Subject: Yapton Y/71/20/RES & Y/72/20/RES

Subject: RE: Yapton_Y/72/20/RES - 70 units

DD427L01-L02 Landscape General Arrangement Plan

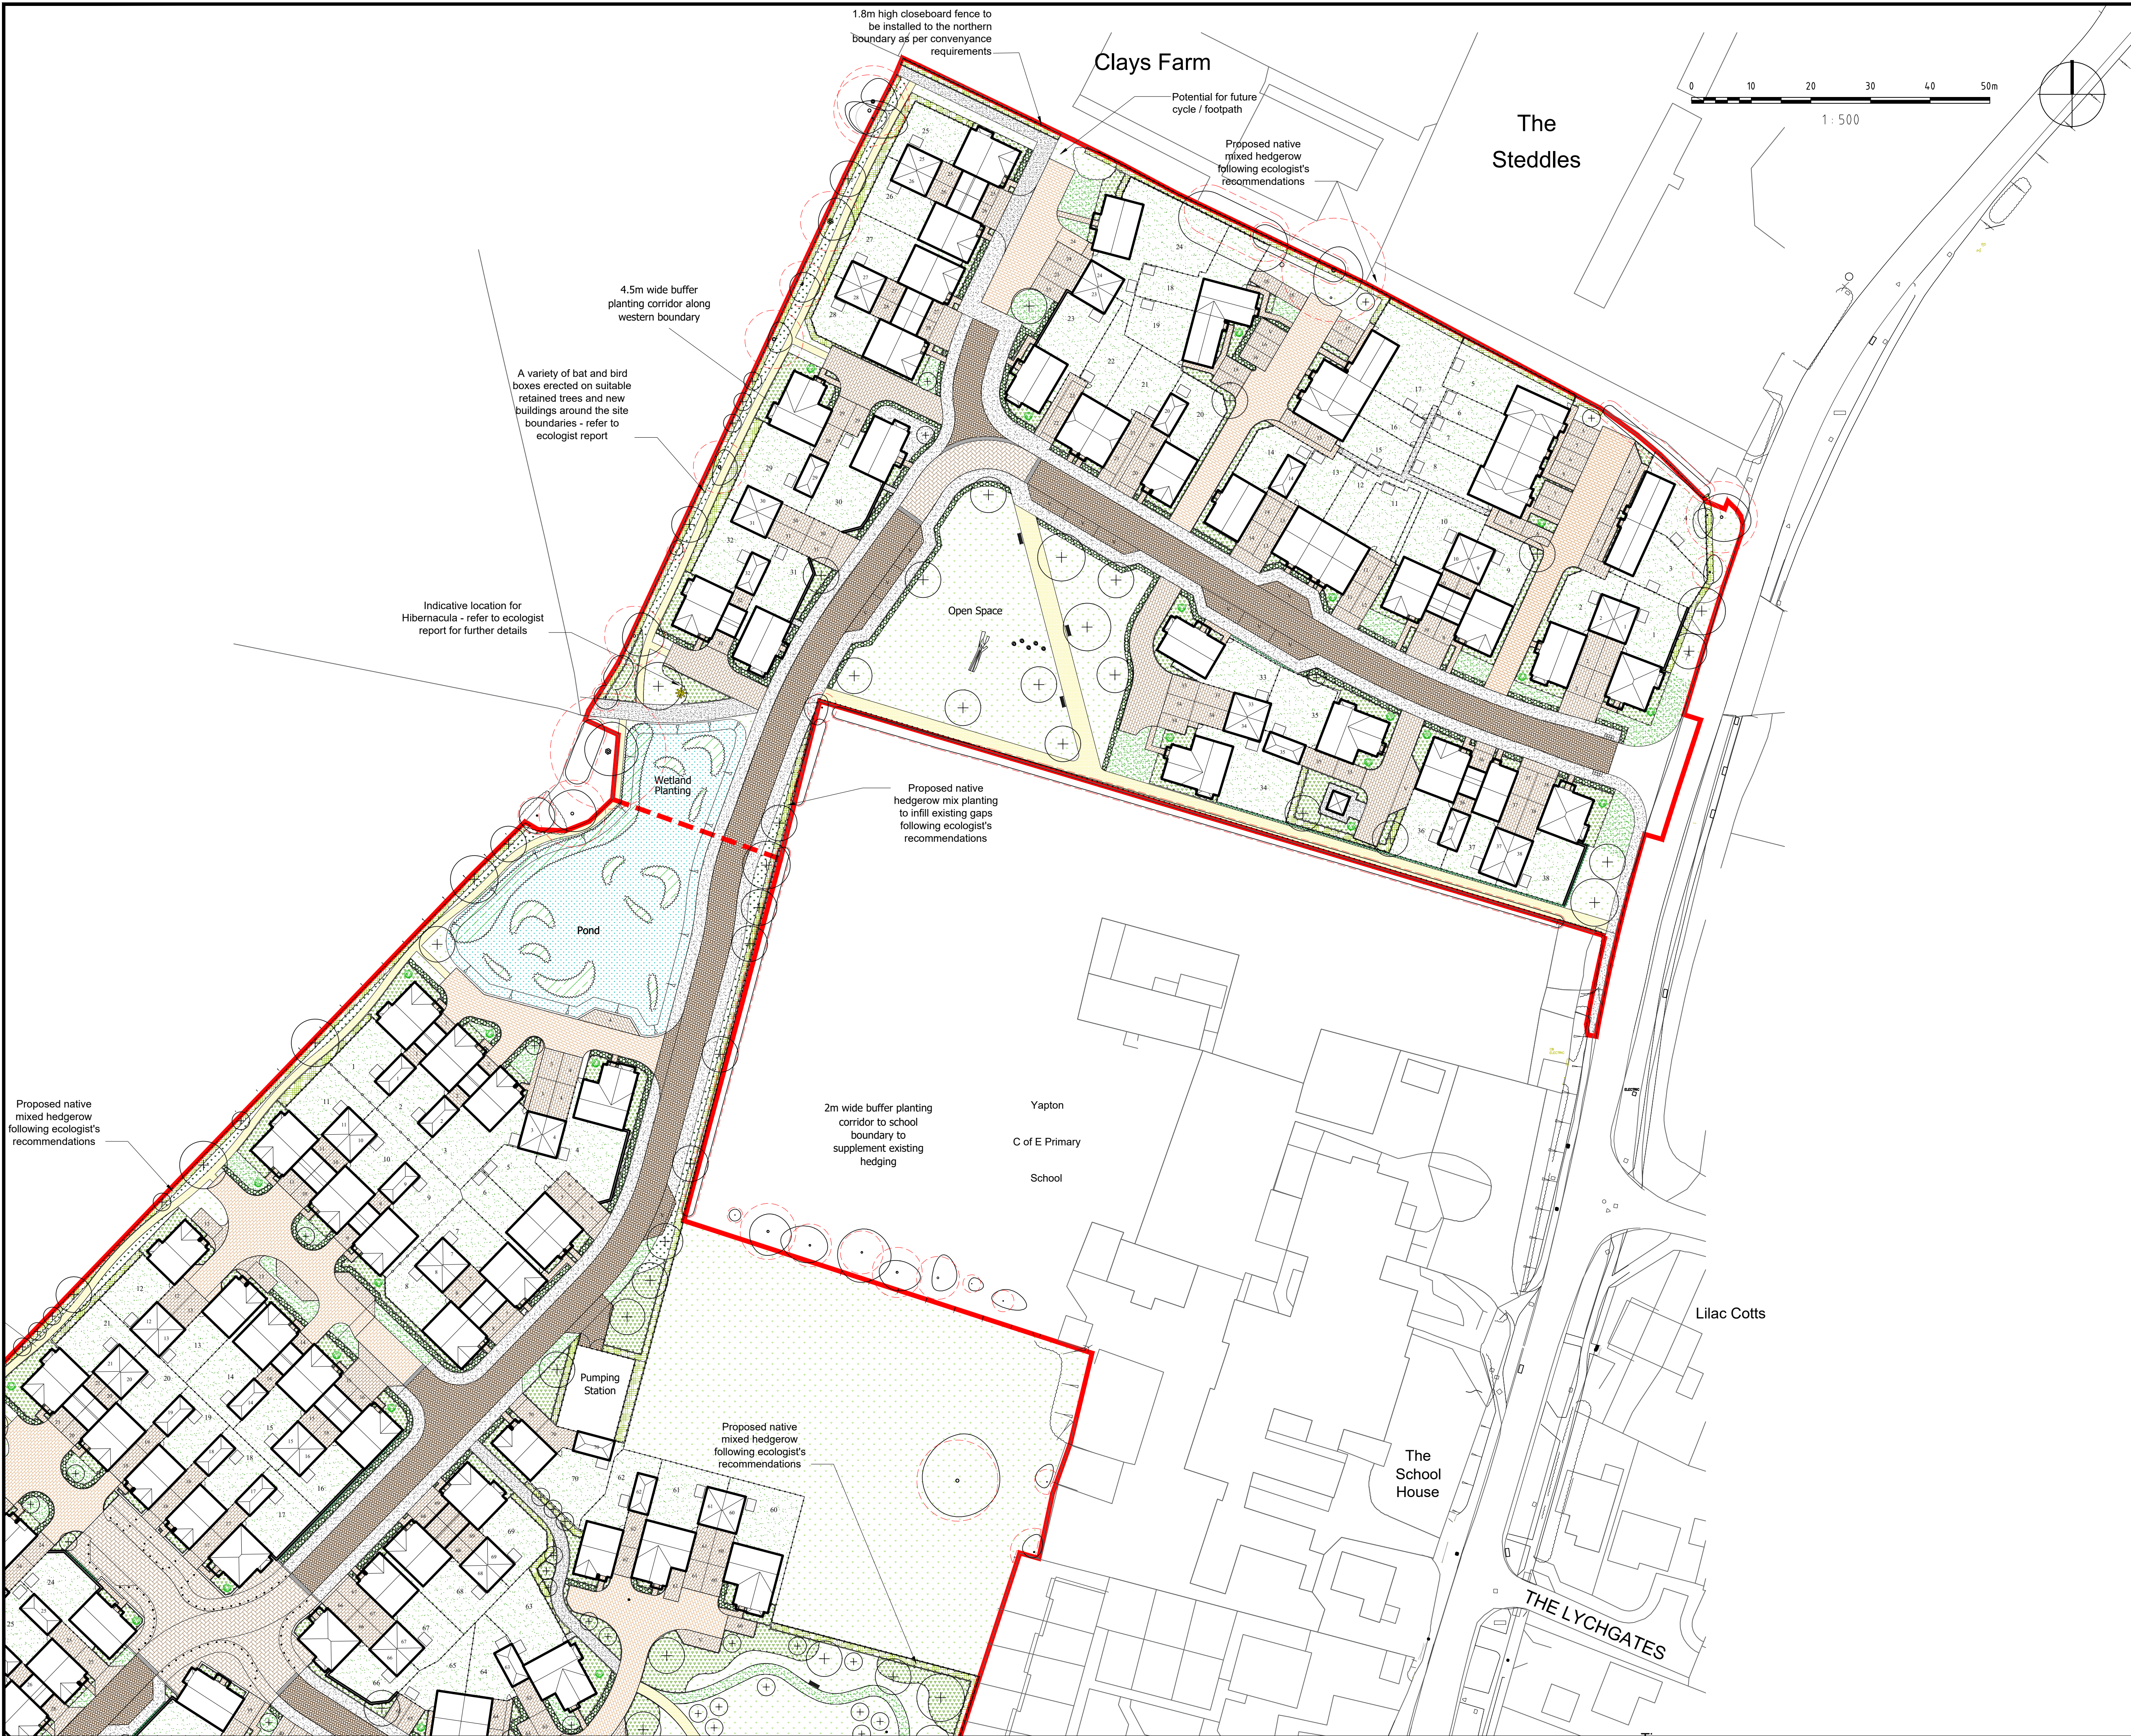
I note our Landscape Officer states *"It is shown in the drawings areas of pathway formation to be 'hoggin' pathways? These may not be classified as a suitable DDA compliant surfacing and attracts maintenance issued in highly trafficked areas. Tarmac pathways would be more suitable for this purpose. (Hoggin pathways would not be supported if to be adopted by the LPA and would need to be tarmac)"*

I have had a look around but cannot find anything to say that hoggin is not DDA compliant. Our emerging Design Guide does not list suitable DDA materials and a google search was not conclusive although the Sensory Trust website stated that hoggin is not suitable in wet areas. I would say therefore that if you are clear that you will not be putting the site forward for adoption and you are content that the hoggin surface will be of decent construction (such that it will not rut & break up easily) then this will be fine.

I note Greenspace comments reiterate the Parish's regards the PROWs and footpath. From available advice, hoggins is listed as a suitable surface material for PROWs, the WSCC Rights Of Way Officer has raised no concerns in this regard. The pathway running along the western boundary of both schemes is included within the site's POS scheme and as such would be subject to the S106 obligations requiring the transfer of land to a Management Company or the Council. Are you able to confirm that you are content that current proposals for the paths are sufficient please?
